WEST SUSSEX COUNTY COUNCIL CONSULTATION

TO:	Arun District Council FAO: Michael Eastham
FROM:	WSCC - Highways Authority
DATE:	24 June 2020
LOCATION:	Land Rear of Lillies Yapton Road Barnham PO22 0AY
SUBJECT:	BN/37/20/DOC Approval of details reserved by condition imposed under ref APP/C3810/W/18/321398 (BN/6/18/RES) relating to Condition No 4 - pedestrian/cycle link. Additional info RSA and Plans received.
DATE OF SITE VISIT:	n/a
RECOMMENDATION:	No Objection
S106 CONTRIBUTION TOTAL:	n/a / £ See below for breakdown.

Discharge of condition 4 - pedestrian/cycle link

SCALE	1:500 @ A2	DATE	FEB 2020
DRAWN	CLS	CHK	JGF
DRAWING NO.	17748-BARN-5-512	REV	B
TITLE	YAPTON ROAD BARNHAM		
DETAILS	Footpath Link & Typical Footway Constructon Detail

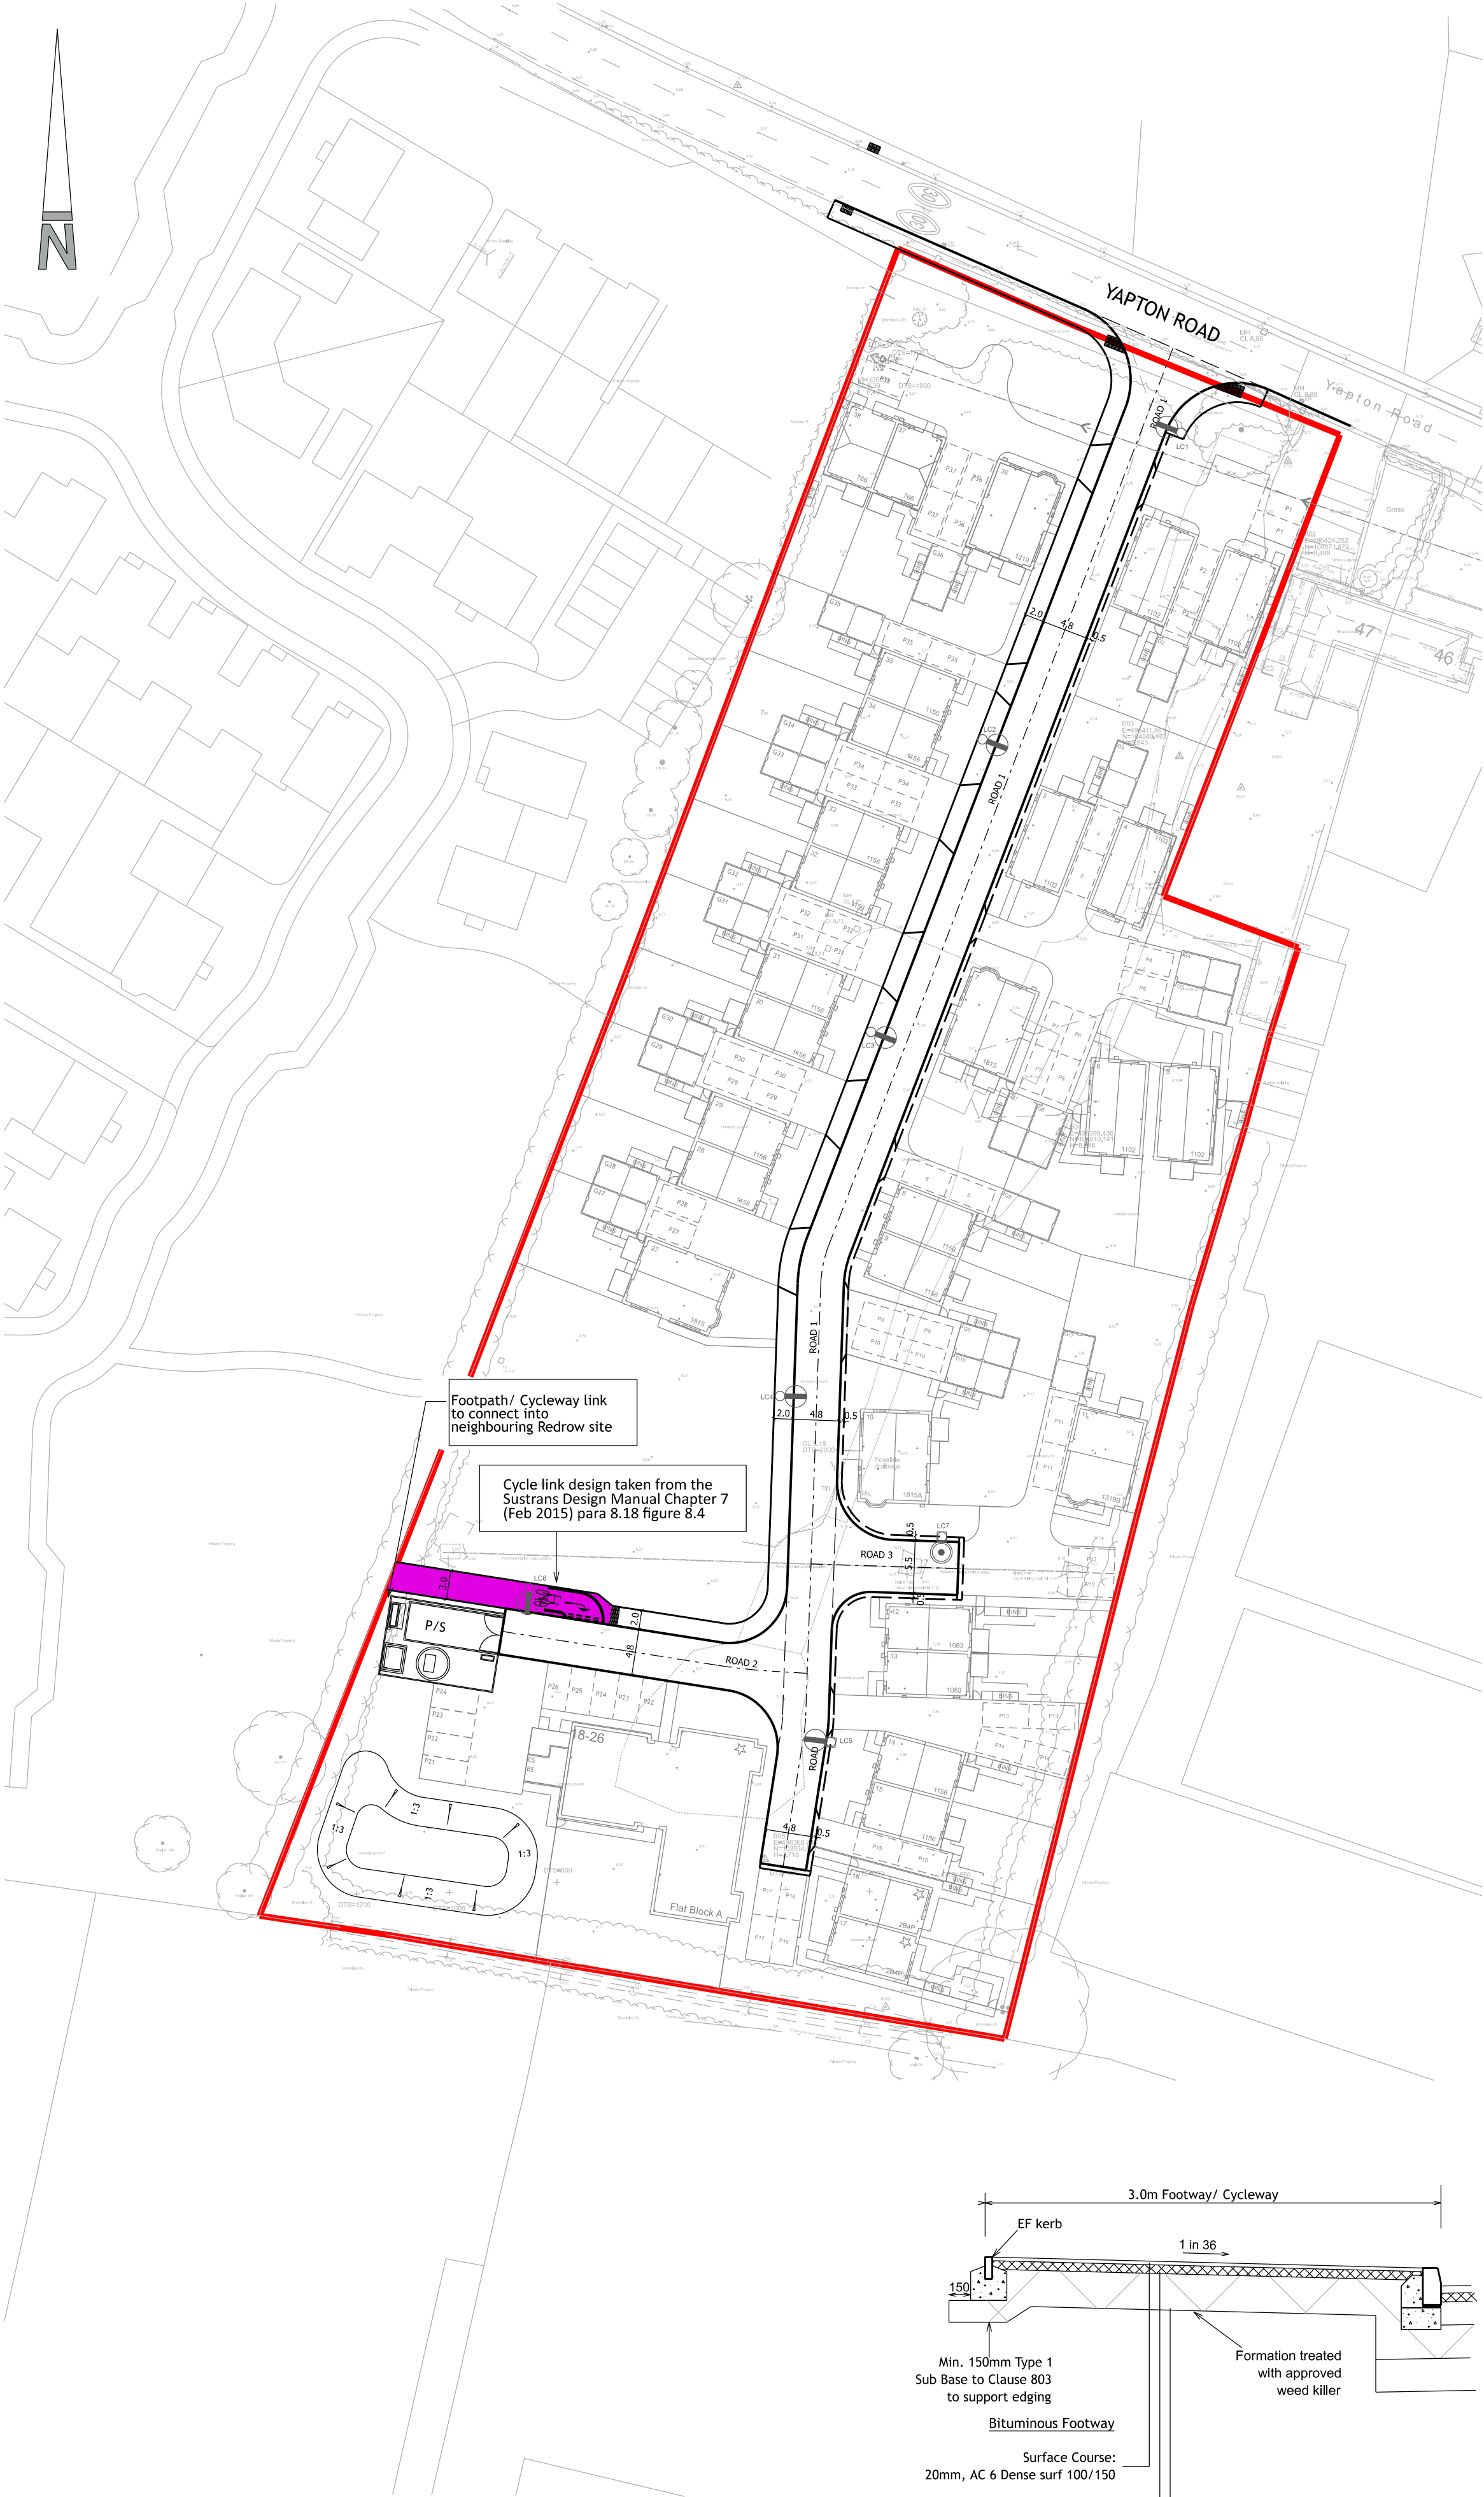
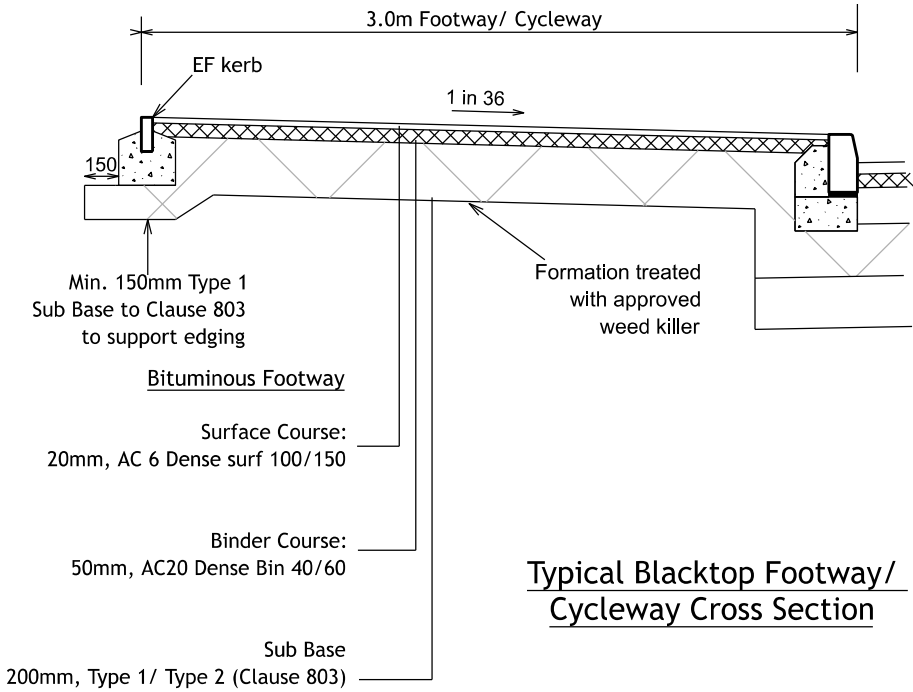
The Stage 1 and 2 road safety audit, RSA decision log, and submitted drawing 17748-BARN-5-512 Rev D prepared by Acorn Projects Limited, has been considered by WSCC as the County Highway Authority.

The auditors, designer and WSCC are all in agreement as per the decision log to include a timber post in the verge, location to be decided at s278 stage, to alert pedestrians/cyclist to the shared use layout. A copy of the decision log is attached for your reference.

WSCC raise no objections in discharging this condition.
